Your Ref: 100653393-001
Our Ref: 23/03382/FULL

Date 18th December 2023

Application No: 23/03382/FULL
Proposal: Erection of dwellinghouse and boundary fence including formation of associated garden ground (Includes demolition of existing outbuilding)
Address: 22 Melbourne Place Bridge Street St Andrews Fife KY16 9EY

CLIENT	MR STAPLES
PROJECT	22 MELBOURNE PLACE ST. ANDREWS KY16 9EY
DRAWING	BLOCK PLAN

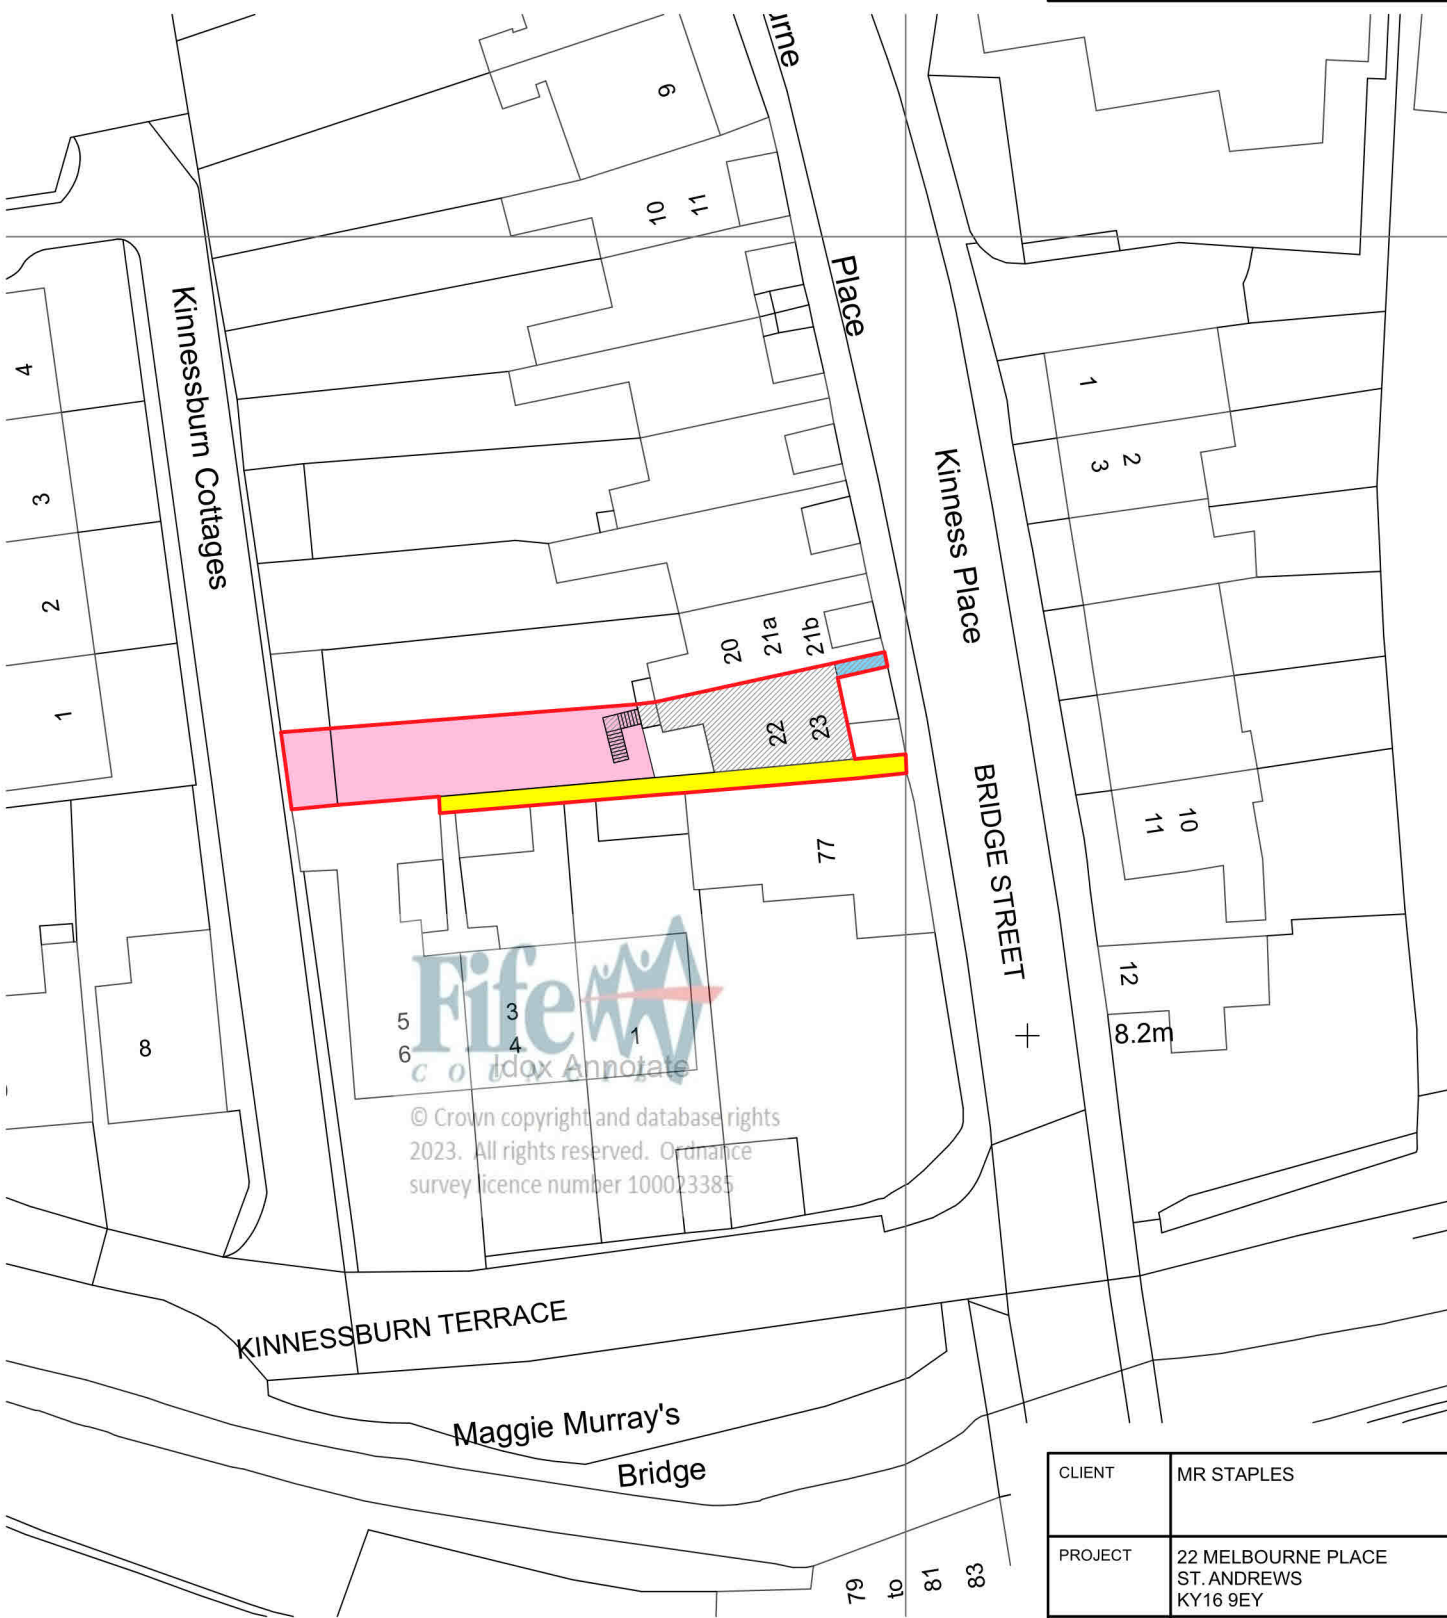
1. The Location plan does not include the shared access to the proposed new dwelling within the red line of the site boundary. Please update the Location plan and block plan to include the shared access within the red line.
2. Please provide a statement detailing how surface water will be dealt with within the development site.
